DECISION DELEGATED TO HEAD OF PLANNING

Application No: H14-0224-24 **Applicant:** Cecil Francis Ltd

Proposal: Details of surface water disposal, external materials, external doors/door frames, window frames and gas/electricity boxes (Conditions 9, 14, 15, 16 and 19 of H14-0706-22)

Location: Cecil Francis Ltd Bear Lane Pinchbeck

Front entrance - plot 2

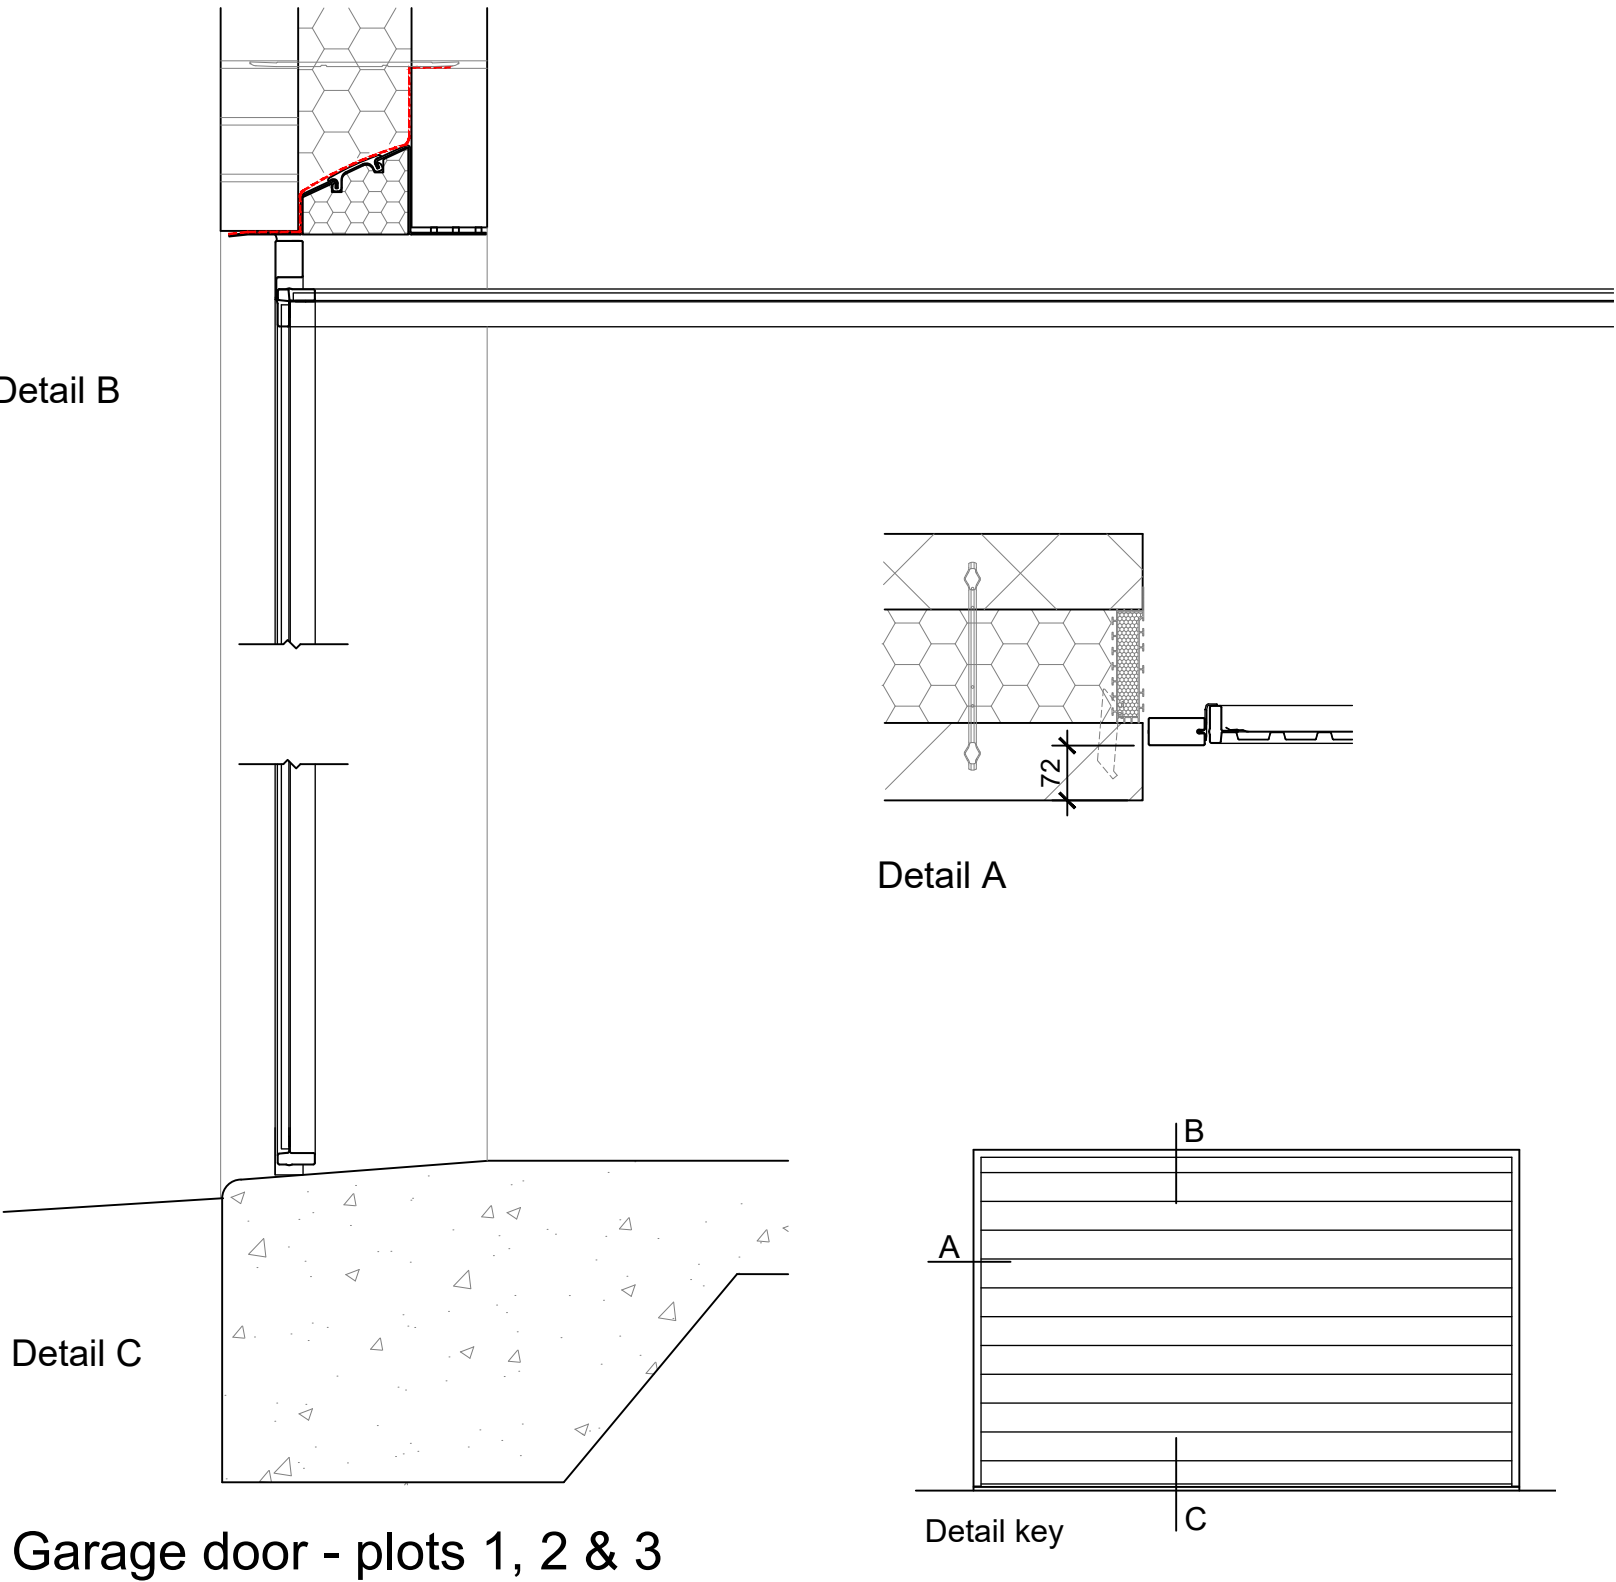
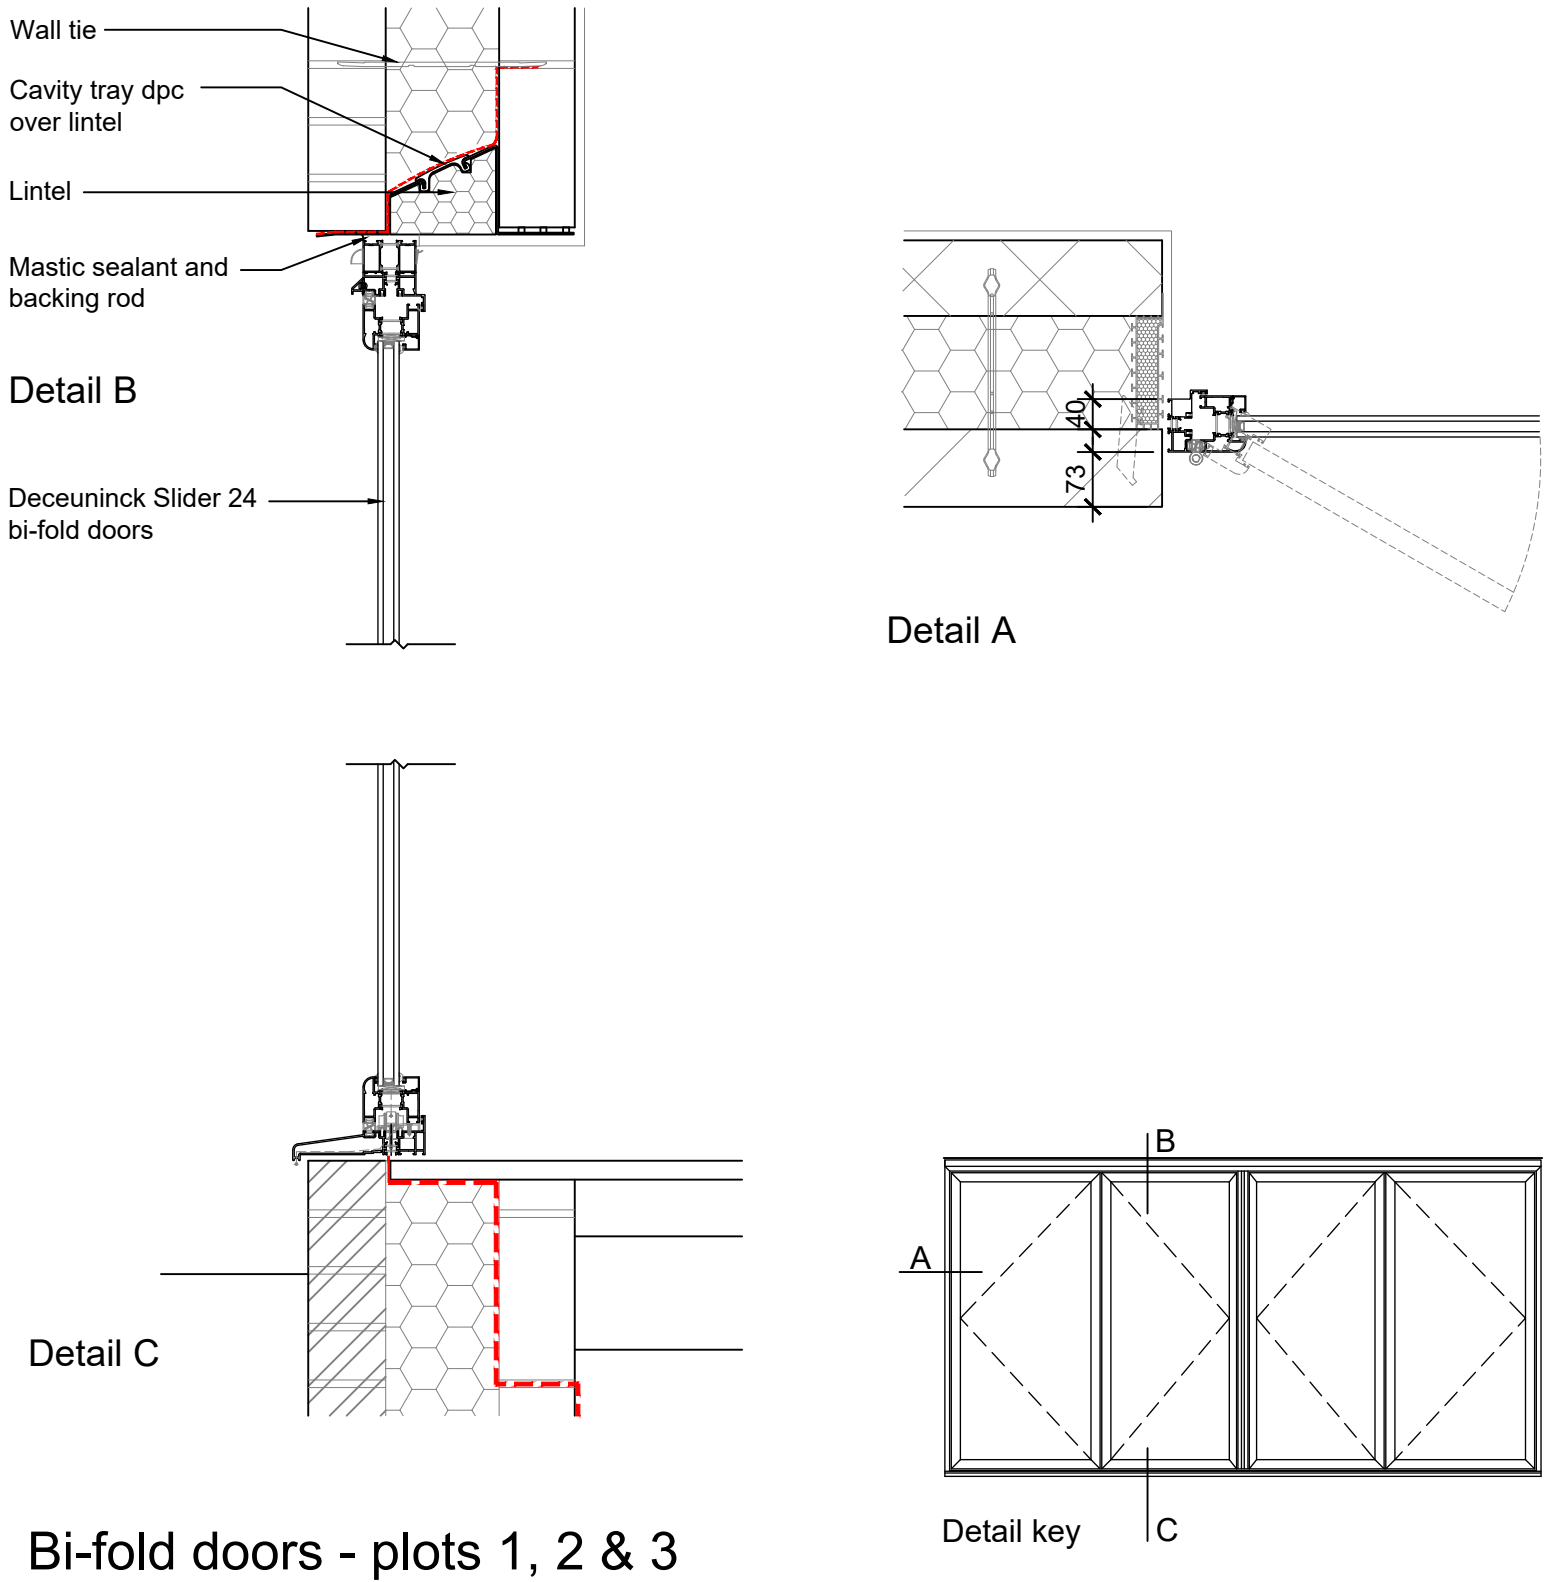
The external entrance doors are to be Deceuninck Heritage 2800 uPVC, anthracite grey. The external bi-fold doors are Deceuninck Slider 24 uPVC, anthracite grey. The garage doors are Aluminium up and over doors, anthracite grey. Window and door jamb, head and sill details are also provided.

Windows are to be Deceuninck Heritage 2800 uPVC, anthracite grey. Window and door jamb, head and sill details are also provided.

The details are considered satisfactory and condition 15 can be discharged.

It is considered that the details are satisfactory and condition 16 can be discharged.

# PUZ-WM60VAA(-BS)

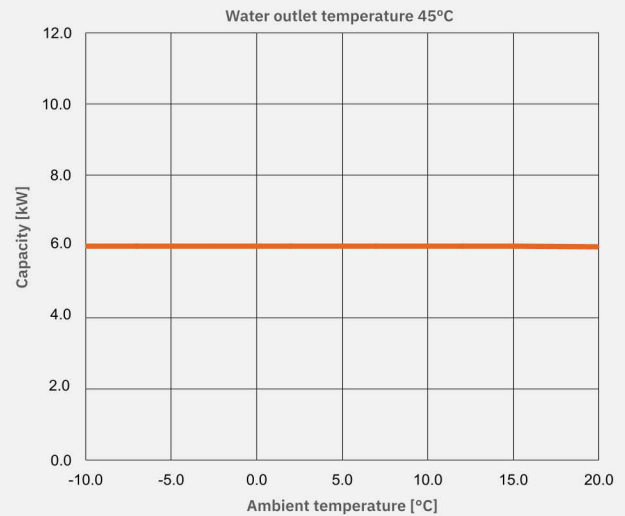
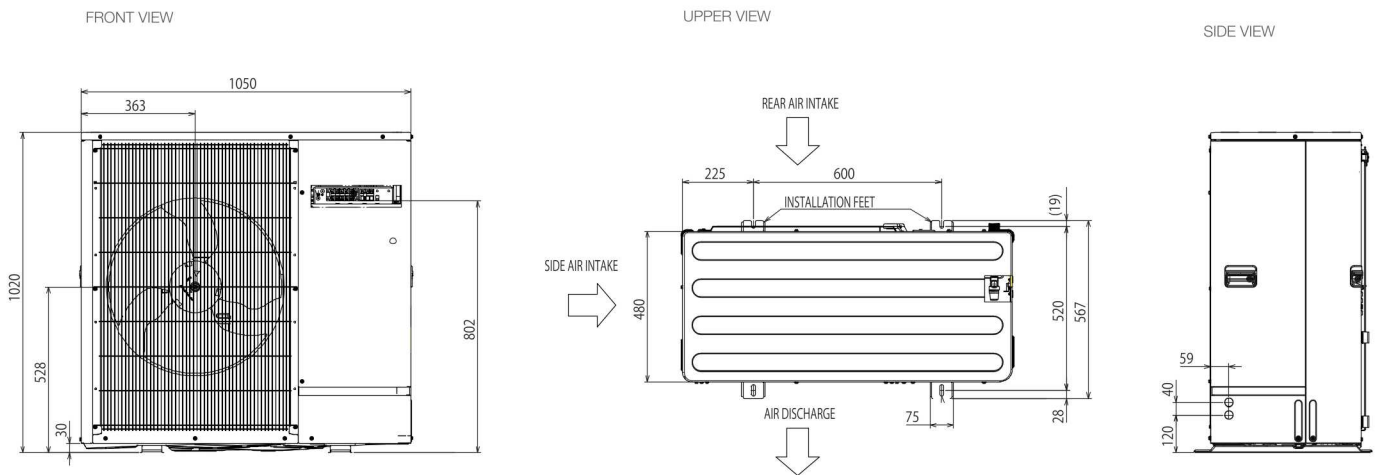
For Plot 2 the electrical cabinet is shown on the south east elevation. It is a standard cabinet in white. The air source heat pump is shown on the south west elevation in the centre of the site away from neighbours. It only comes in a standard grey colour and is an Ecodan R32 Air Source Heat pump.

For Plots 1 and 3 the electrical cabinet is shown on the north west elevation. It is a standard cabinet in white. The air source heat pump is shown on the south west elevation in the centre of the site away from neighbours on the rear elevation. It only comes in a standard grey colour and is an Ecodan R32 Air Source Heat pump.

The submitted details are considered satisfactory.
